# **A1 in Northumberland: Morpeth to Ellingham**

**Scheme Number: TR010059**

## **Appendix A Response to RR-04 Environment Agency**

<b>Regulation Reference:</b>	APFP Regulation Rule 8(1)(c)
<b>Planning Inspectorate Scheme Reference</b>	TR010059
<b>Application Document Reference</b>	TR010059/7.9.1
<b>Author:</b>	A1 in Northumberland: Morpeth to Ellingham Project Team, Highways England

Drawing Title Figure 9.2 Habitats of Principal Importance and Non-Statutory Sites
Page 1 of 4

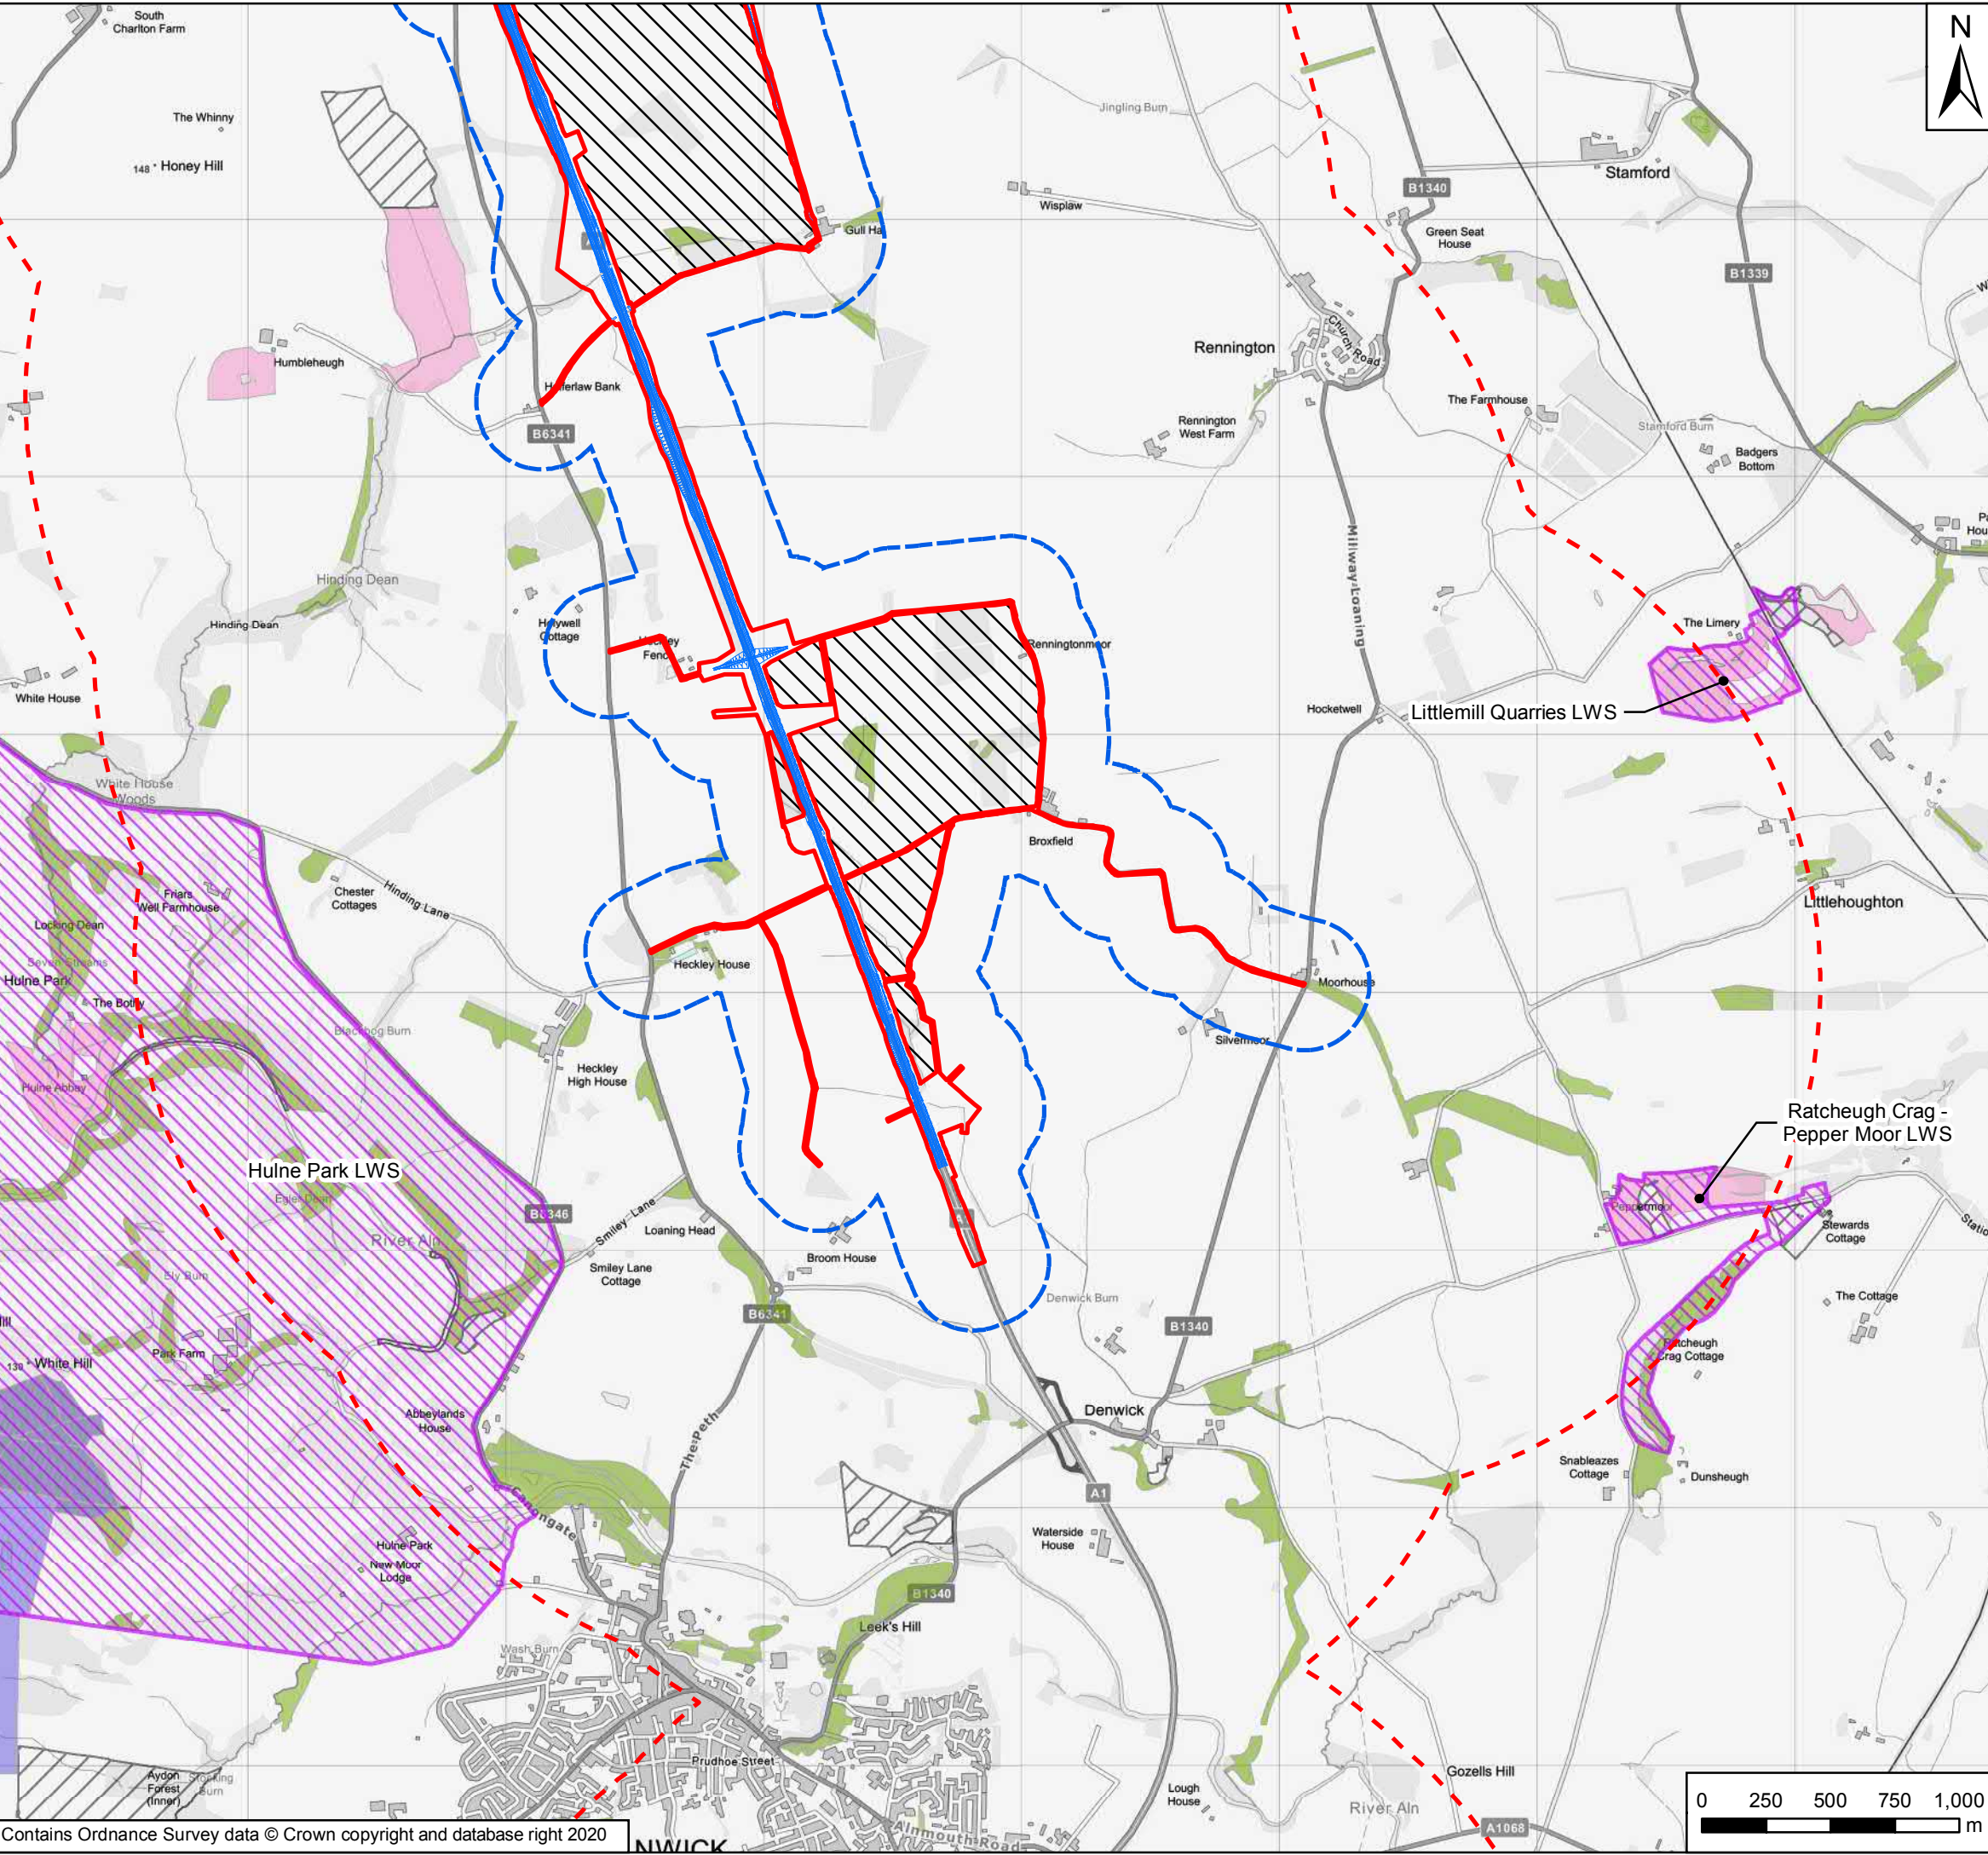
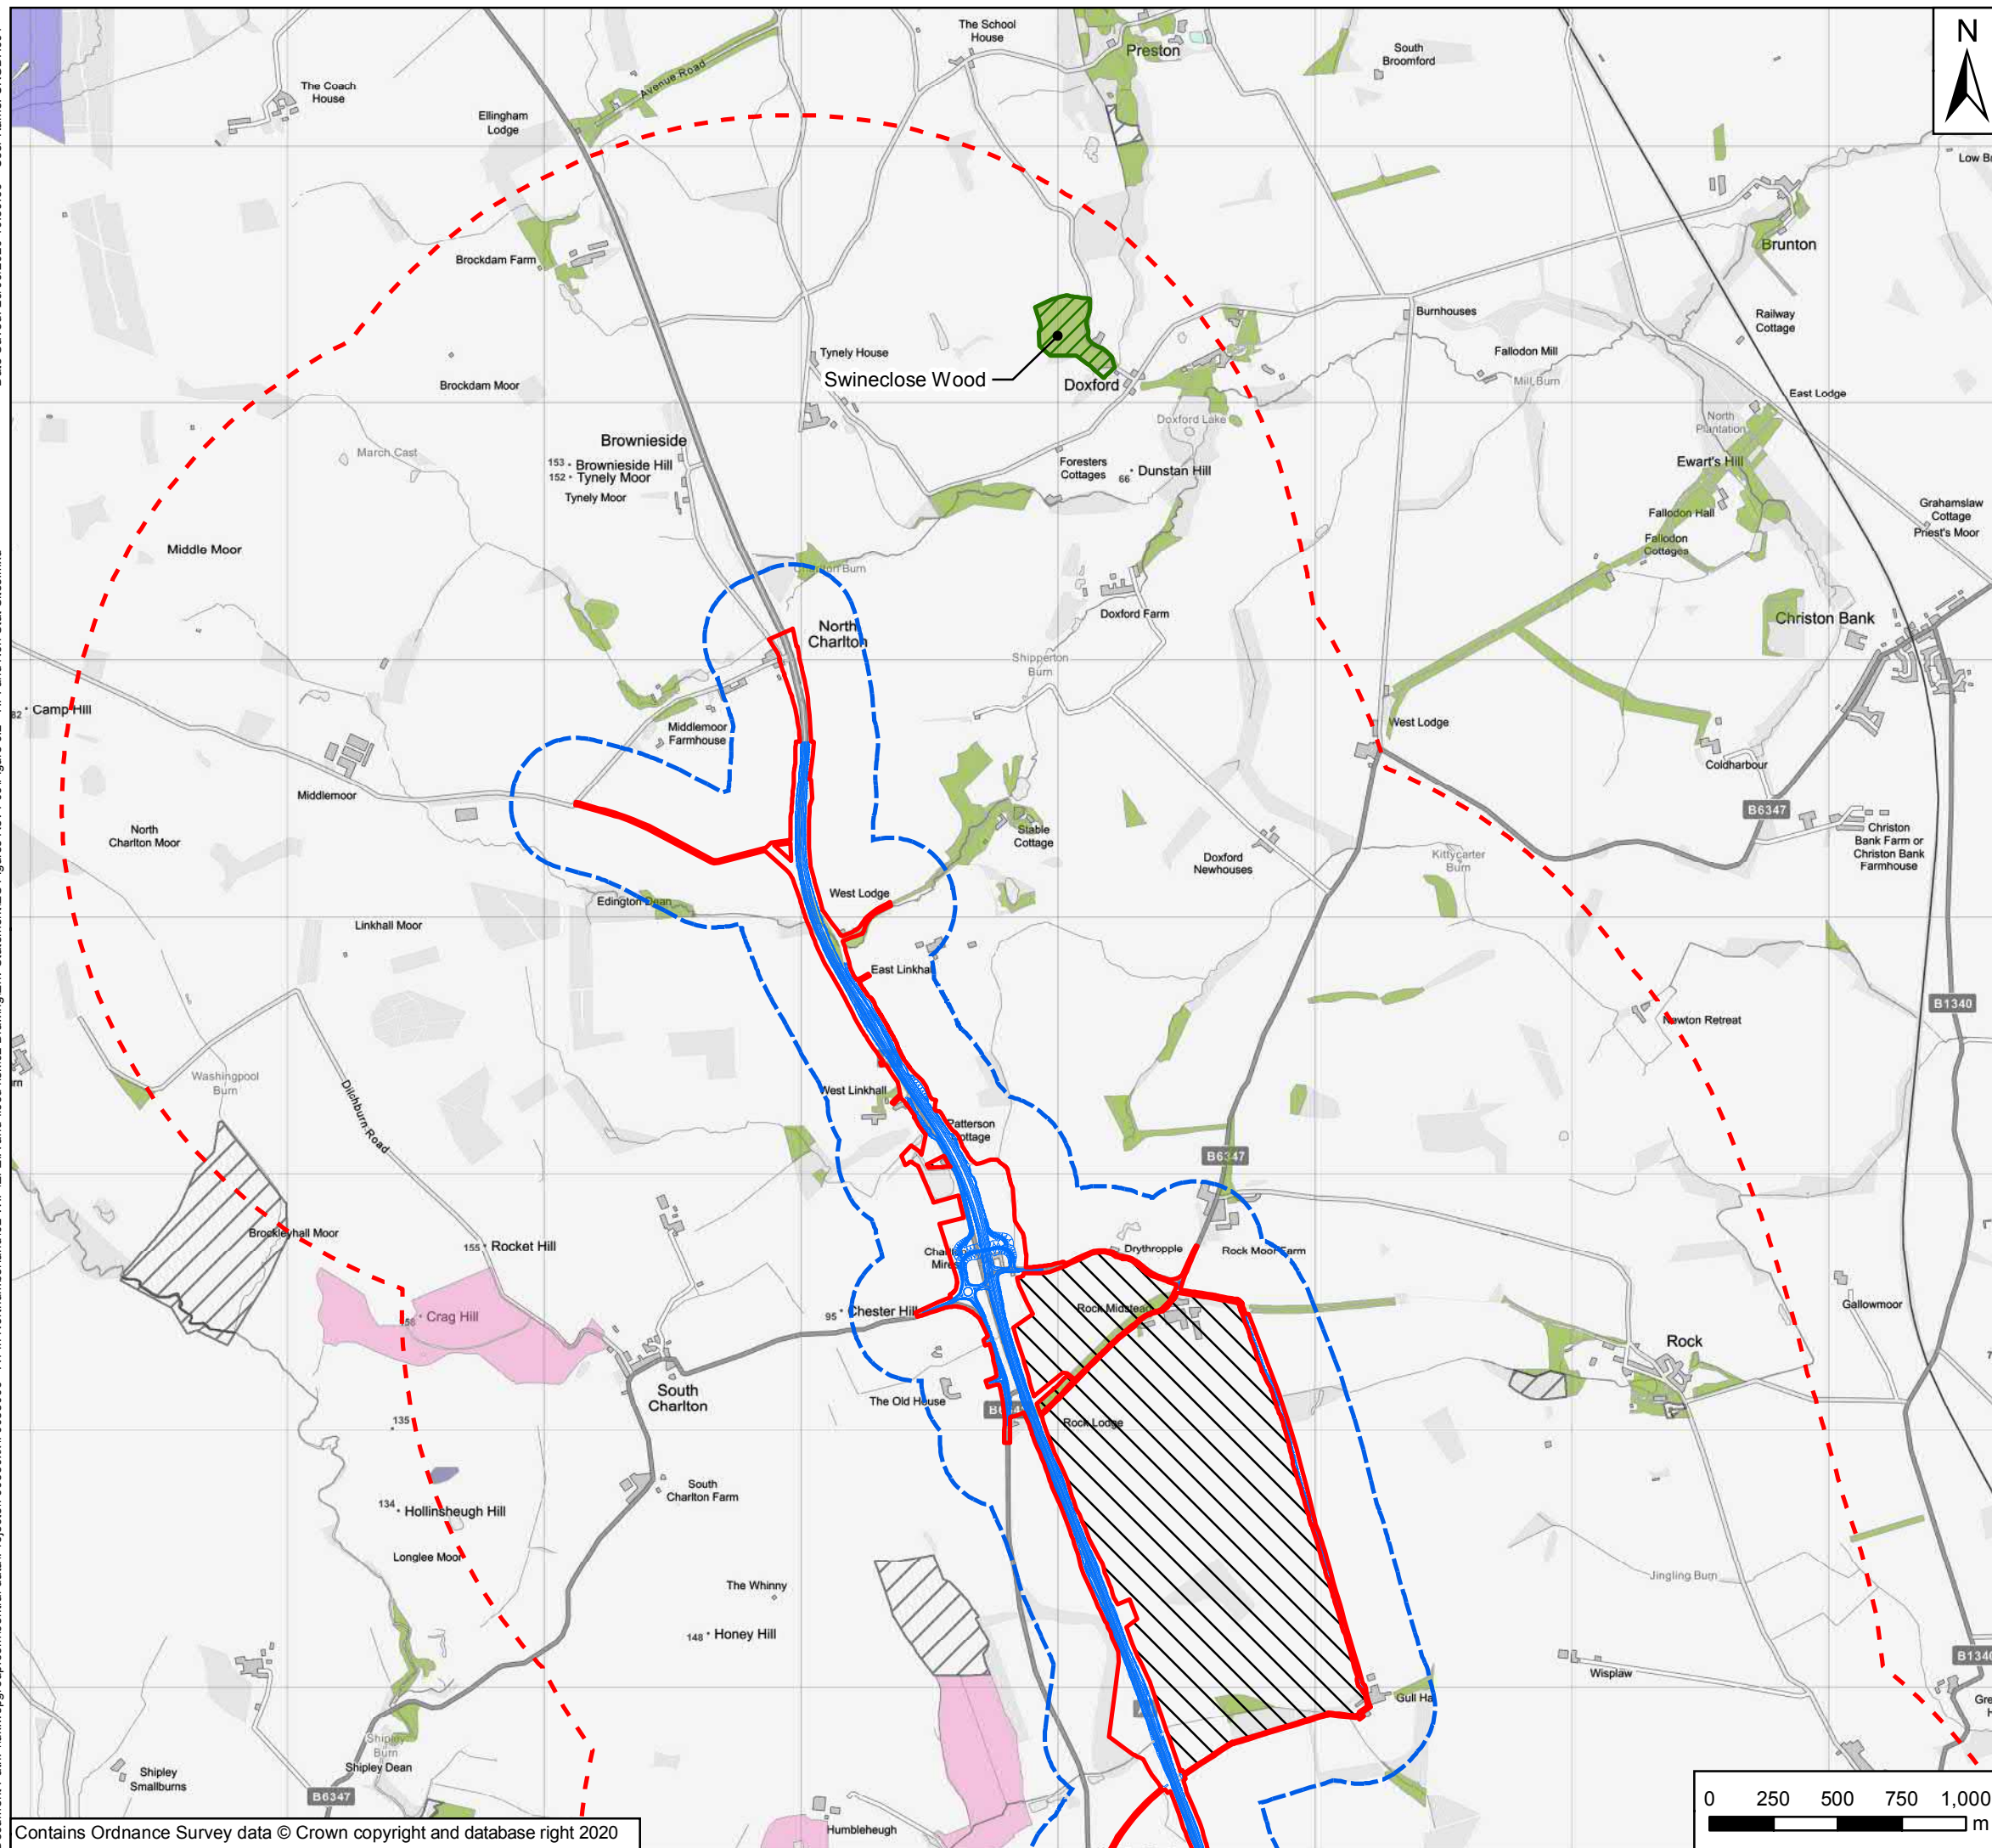
A.11 Habitats of Principle Importance: Issue and impact	Part A summarises a loss of approximately 200m of River Habitat of Principle Importance (HPI). This is not compliant with NPPF, which seeks to protect and enhance the environment. Stating that a 5% loss is not classed as a biodiversity net loss is not compliant with current best practice, as stated in our subsection; Biodiversity No Net Loss.	<p>A response regarding the definition of No Net Loss is detailed in A.4 above. Applying this definition, it follows that the assessment is appropriate.</p> <p>It is not considered viable to create new lengths of watercourse as this would rely on a water source to create the habitat. A water source cannot be created and therefore, in the absence of a natural source or diversion of water from an existing watercourse (which could have adverse effects on the existing water course and/or flood management), a watercourse cannot be readily created. As such, mitigation measures have been designed to address the net loss of approximately 200m of watercourse associated with Part A. These include improvements to approximately 850m of Longdike Burn (see EM047 of Chapter 9 Part A [APP-048] of the ES) and the design of new channels to increase their biodiversity value (see EM041 of Chapter 9 Part A [APP-048] of the ES). This would include the design of channels that are of greater biodiversity value than those lost to Part A of the Scheme.</p> <p>The BNNL assessment should be considered separately from the assessment detailed within Chapter 9: Biodiversity Part A [APP-048] and Part B [APP-049] of the ES. The Scheme is a NSIP and is therefore governed by the NPS NN rather than the NPPF. Therefore, there is currently no legal requirement to achieve no net loss or net gains in biodiversity. The BNNL calculations have been completed to inform the Applicant's internal requirement to achieve no net loss across all its schemes cumulatively (at a national scale). This is not linked to the Development Consent Order (DCO) process and is an internal requirement. The assessment has been undertaken as a best practice measure but does not represent a commitment to achieve no net loss for the Scheme. The Applicant is currently preparing a</p>

<p>A.13 Habitats of Principle Importance: Issue and impact</p>	<p>Culverting of watercourses drastically decreases their function, productivity and ecological value. This loss has been recognised in Chapter 10, section 10.10.31 where it states 'Overall, there is an increase in the total length of culverts and as a result there would be a permanent loss of natural channel associated with Part A along each of the watercourses in the Study Area'.</p>	<p>The Culvert Mitigation Summary (Annex A) submitted at Deadline 1 summarises the mitigation proposed for each watercourse crossing. Specific mitigation measures to maintain the function of the watercourse are discussed further below. The Scheme also maintains the hydraulic connectivity of all watercourses crossed by the Scheme to maintain downstream hydromorphological conditions.</p>
<p>A.14 Habitats of Principle Importance: Issue and impact</p>	<p>Any overall loss and impact will also require considerations in terms of the WFD. Furthermore, Chapter 9 section 9.8.9 states 'With regards to potential impacts to watercourses (running water – G2), excluding ditches, Part A would result in the direct, permanent loss of approximately 750 m of watercourse. Loss would occur to facilitate the construction/extension of culverts. This includes the loss of approximately 715 m of watercourses considered of Local importance and approximately 35 m of watercourse considered of National importance, Longdike Burn.'</p> <p>This is much greater than the 200m the ES summarises. It is assumed that the applicant has come to this conclusion due to the 540m of new channel due to be created as stated in section 9.9.6. However not only this is a net loss, but this is not a like for like replacement and channel realignments are unlikely to carry the same biodiversity value as previous channels. No designs for new channels have been submitted, and plans appear to show straightened channels, which provide a very low biodiversity value.</p>	<p>The reinstatement of new channel has been taken into account meaning that there is a net loss in Part A of c.200m. The assessment considered that the existing channels that are to be realigned are small watercourses that are already very straight and trapezoidal in shape, and with low ecological value and not identified to be suitable for fish. The proposed design of these sections of realigned channel would introduce features within the channel to provide greater variation to flow and habitat form. It is not considered appropriate to provide a meandering channel for these small features, particularly as this would be a significant change to the current channel form and not in proportion to the small nature of the watercourse. However whilst the realigned channel is straight, the proposals to include in-channel features will provide variation within the channel beyond that which is currently present which is considered more appropriate for the size of these features. The proposed in-channel features will be developed further during the detailed design in consultation with the EA and Local Authority, secured through requirement 8 of the DCO [App-014].</p> <p>The design for the crossing of the Longdike Burn comprises an extension to the existing bridge structure that will maintain the natural riverbed. A mammal ledge will also be added.</p>

Reference	Comment from Relevant Representation	Applicant's Response
		<p>Biodiversity No Net Loss Assessment in line with Defra Metric 2.0 for the Scheme. This will be submitted at Deadline 2.</p> <p>The 5% loss of watercourse for Part A is assigned as biodiversity no net loss in accordance with the response provided to question A.4. Within the assessment, no net loss has a range of 95-104% of the baseline in accordance with GN36. GN36 is currently the only published standard available.</p>
<p>A.12 Habitats of Principle Importance: Issue and impact</p>	<p>Considering Part A includes a new offline alignment with several new culverts and the extension of others within the online widening section and given this level of impact upon watercourses, the loss of only 200m (5%) of is not ecologically sound. No mitigation or compensation is offered for this loss.</p>	<p>As discussed in A.11 above, it is not considered viable to create new lengths of watercourse. As such, mitigation measures have been designed to address the net loss of approximately 200m of watercourse associated with Part A. These include improvements to approximately 850m of Longdike Burn (see EM047 of Chapter 9: Biodiversity Part A [APP-048] of the ES) and the design of new channels to increase their biodiversity value (see EM041 of Chapter 9: Biodiversity Part A [APP-048] of the ES). This would include the design of channels that are of greater biodiversity value than those lost to Part A of the Scheme.</p>
